OXFORDSHIRE COUNTY COUNCIL'S RESPONSE TO CONSULTATION ON THE FOLLOWING DEVELOPMENT PROPOSAL

Application no: 21/01119/OUT

Proposal: Outline planning application for the re-development of the Banbury Oil Depot to include the demolition/removal of buildings and other structures associated with the oil depot use and the erection of up to 143 apartments and up to 166m² of community and/or retail and/or commercial space (Class Use E and/or F2) with all matters (relating to appearance landscaping, scale and layout) reserved except for access off Tramway Road

Transport Schedule

JOB TITLE		Banbury Oil Depot		CLIENT		The Motor Fuel Group	
DRAWING TITLE							
Proposed Development Access							
Footway Crossover and Vehicle Tracking (Refuse)							
SCALE	DRAWN BY	DATE	DRAWING No	REVISION			
@A3	DN	Sept 21	22251-04-1

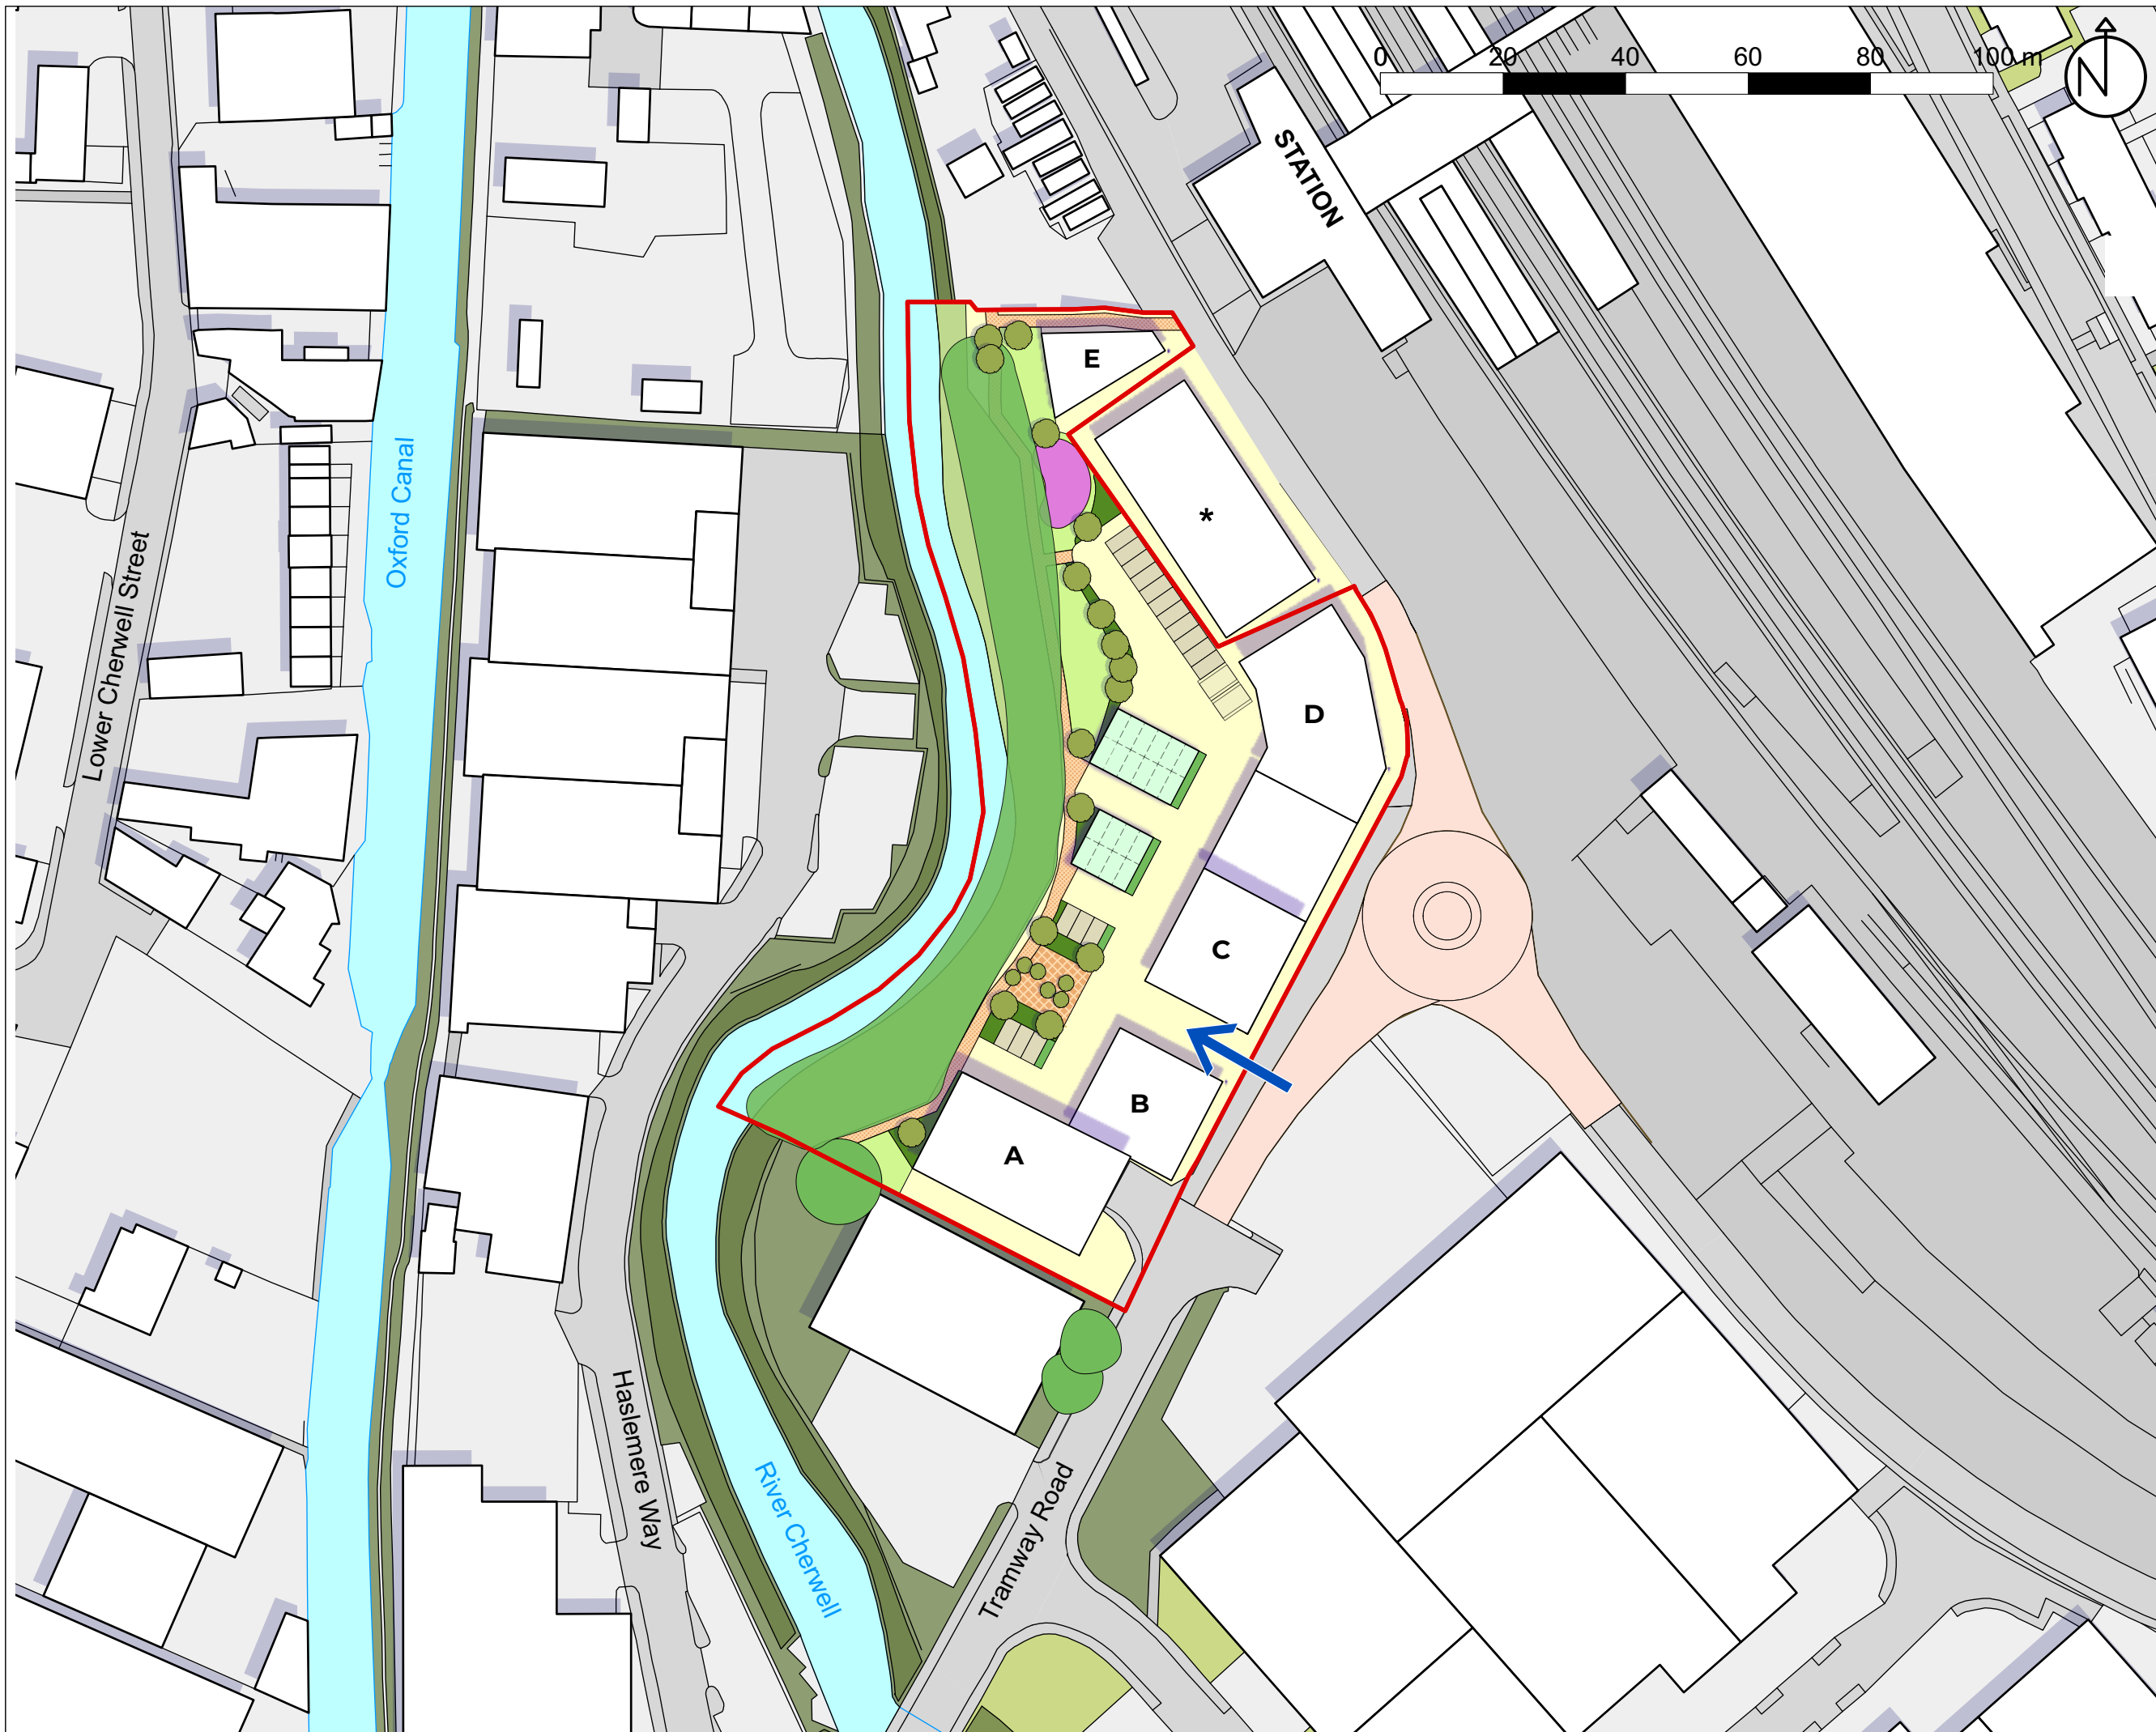
The Applicant has however failed to provide the requested visibility splay drawing for the site access in our earlier comments to address our safety concerns. A scaled dimensioned access drawing superimposed with visibility splays demonstrating compliance with Standards for all road users (pedestrians, cyclist, and motorists) in both directions within the vicinity of the access will be needed to support of the Road Safety Audit Report. This would allay any doubts regarding highway safety concerns for road user in that area.

That said, on receipt of the requested visibility splay drawing the Transport Officer would be able to complete its review for this outline stage of the planning application.
